LORSON RANCH AT JIMMY CAMP

SKETCH PLAN AMENDMENT No. 2 LETTER OF INTENT

MINOR SKETCH PLAN AMENDMENT #2

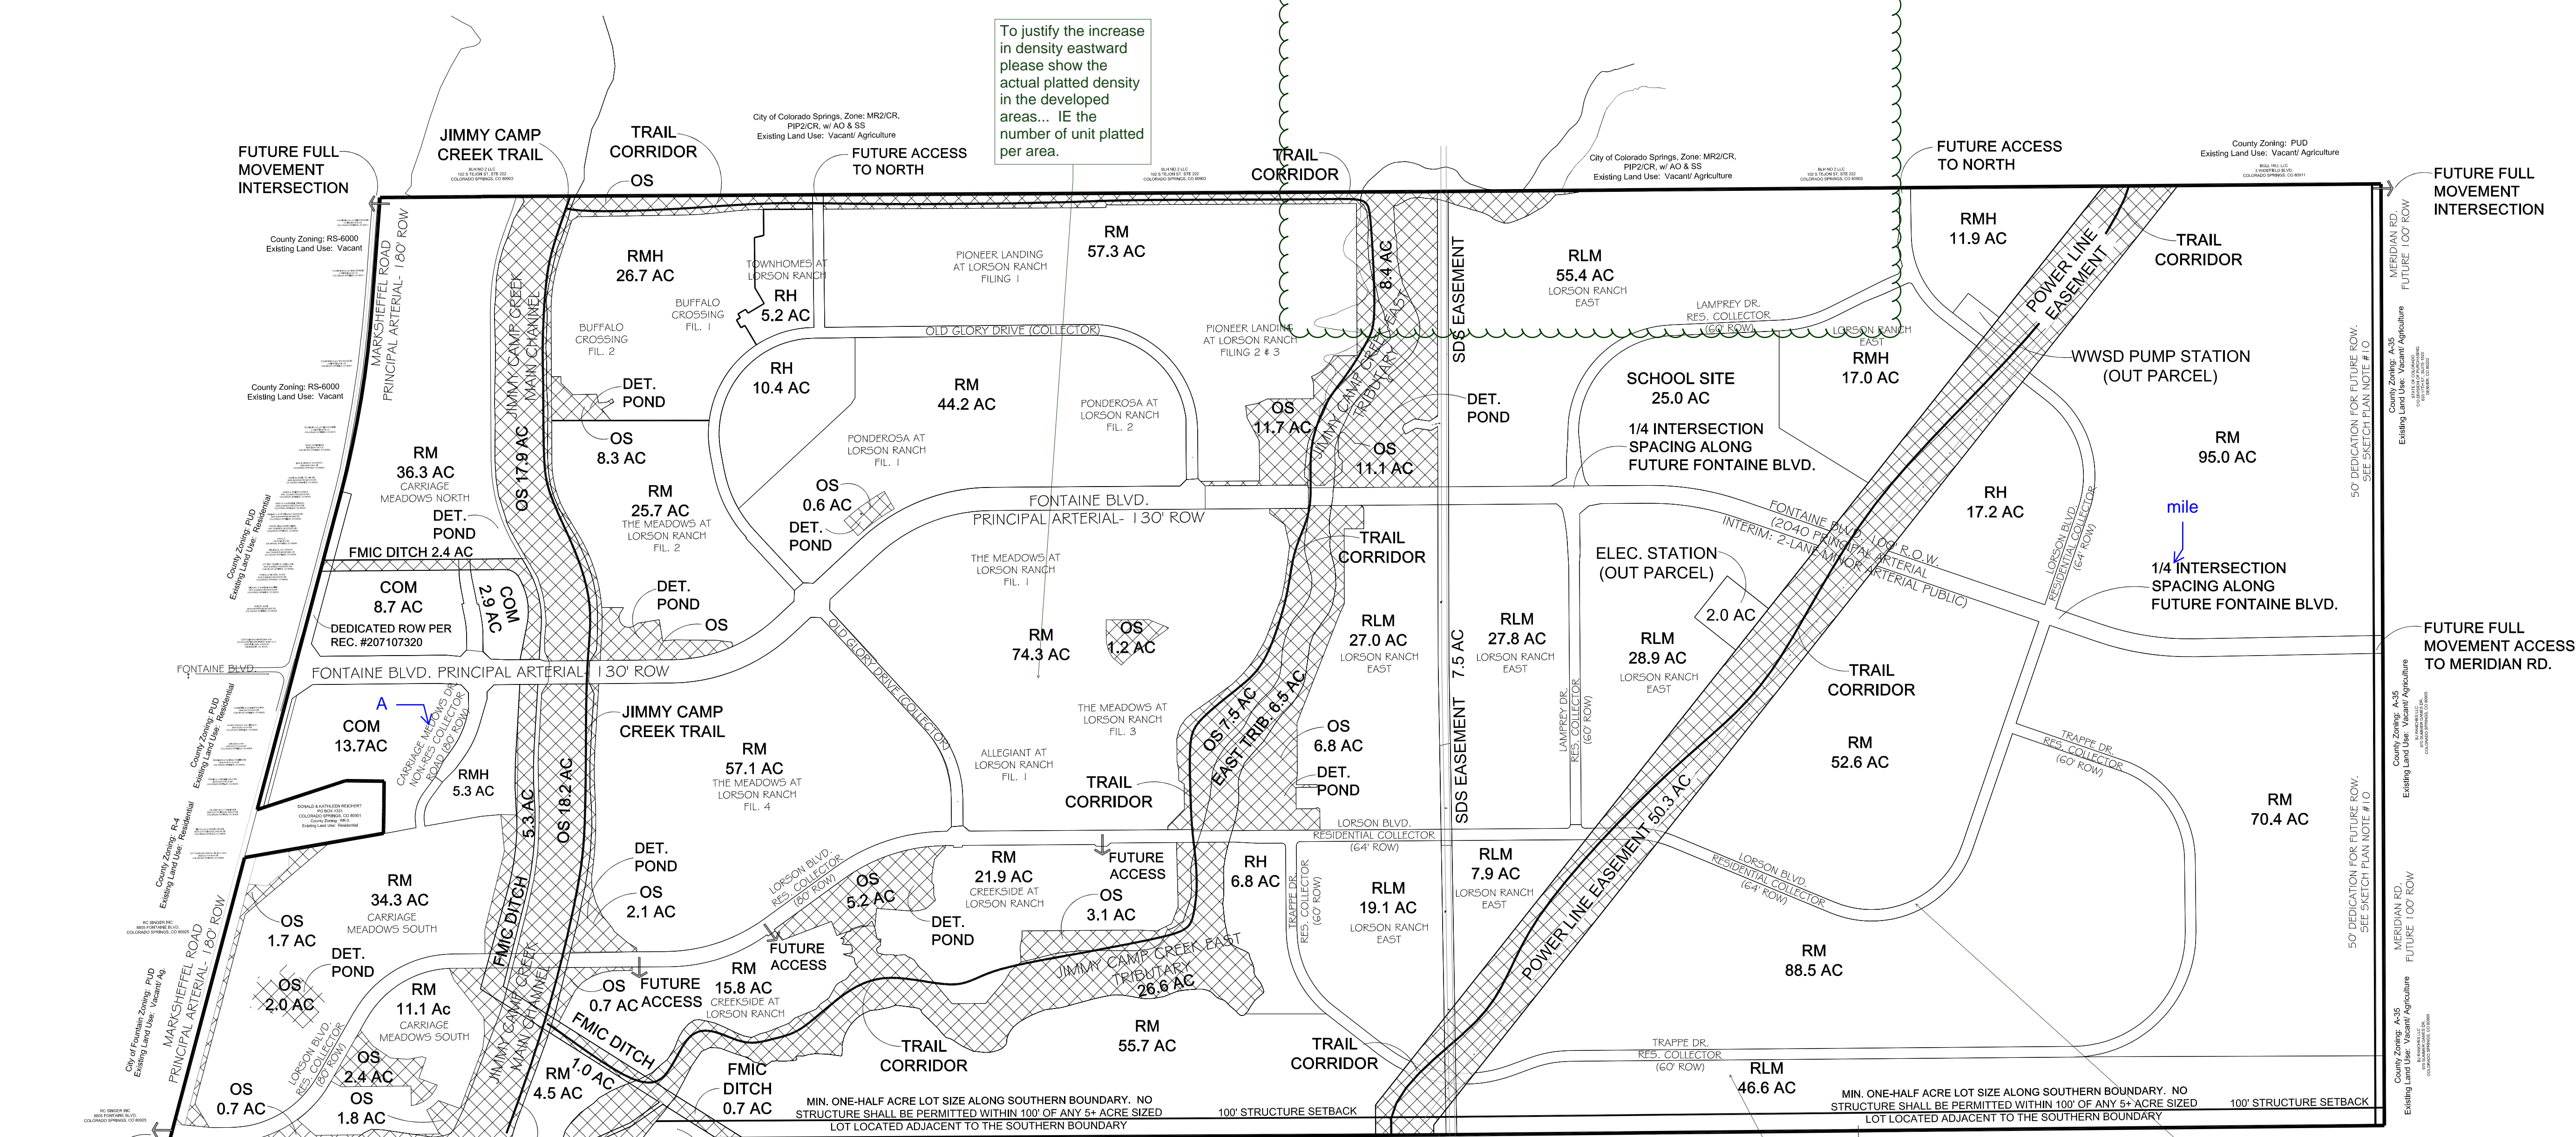
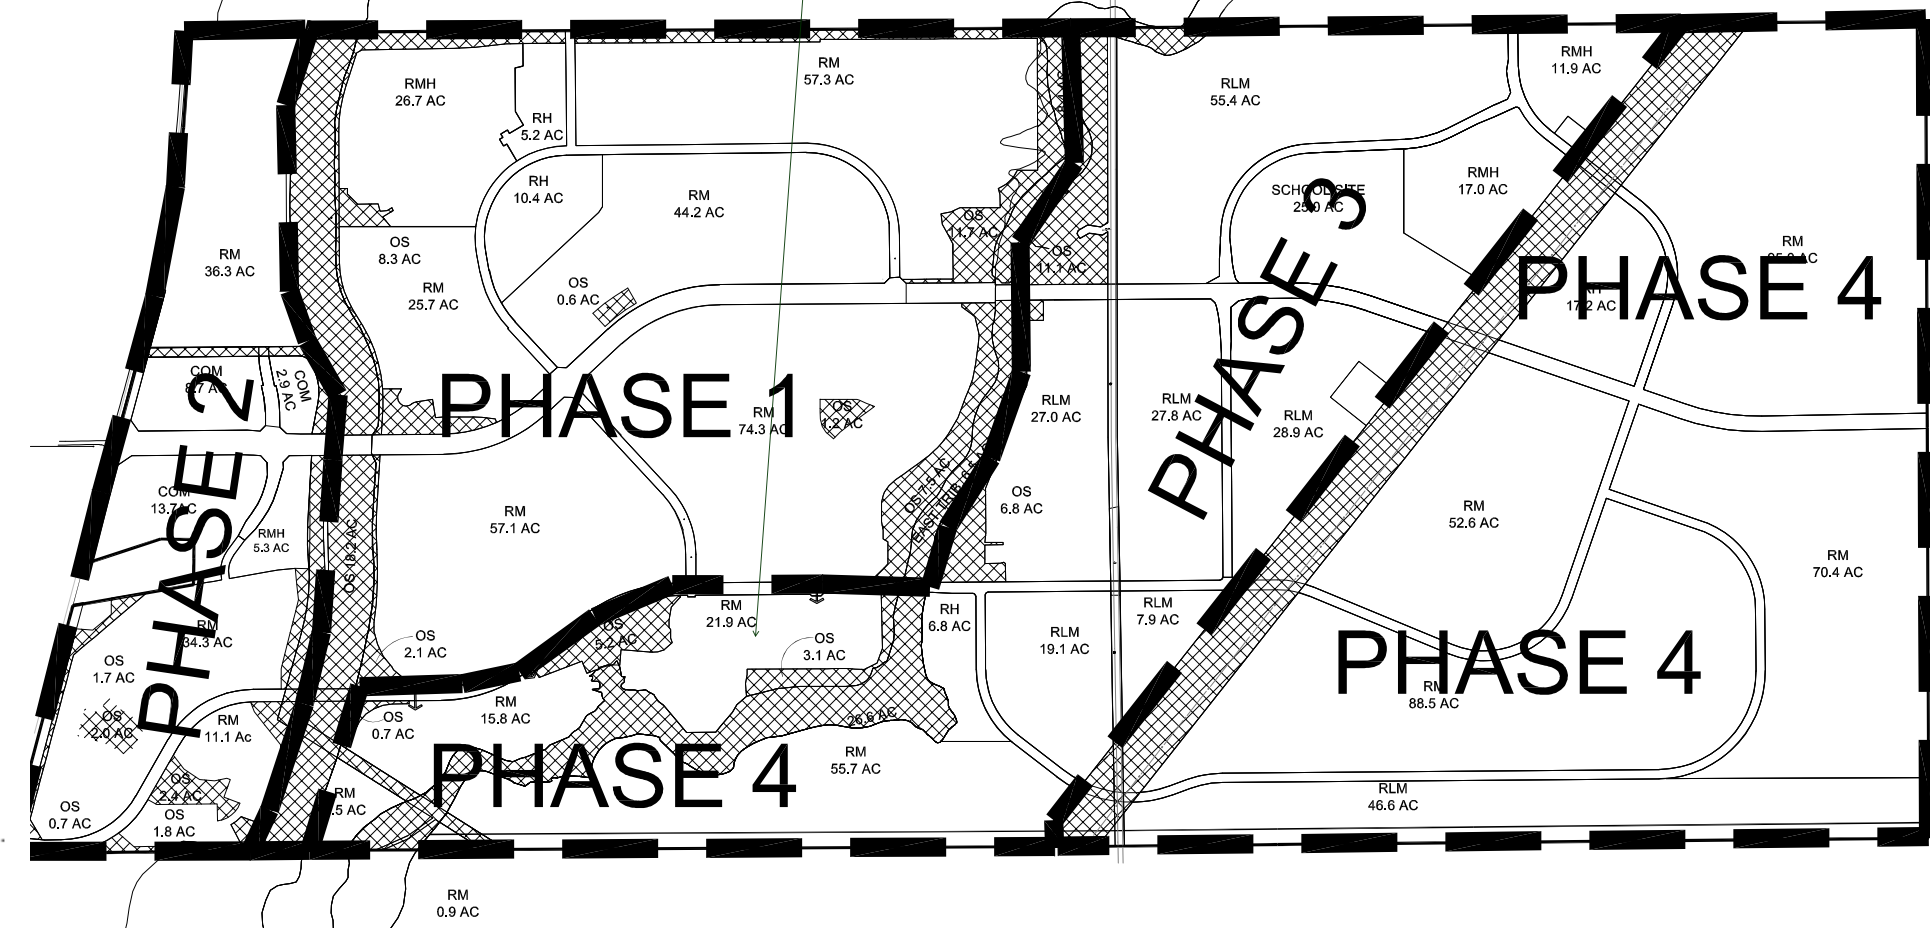
remove the connection road; modify the location of the sites...the entire development is apart of the app with secific clouded (proposed changes)

See skp plan redlines
for further clarification

Add a note to the face of the SKP to identify this.
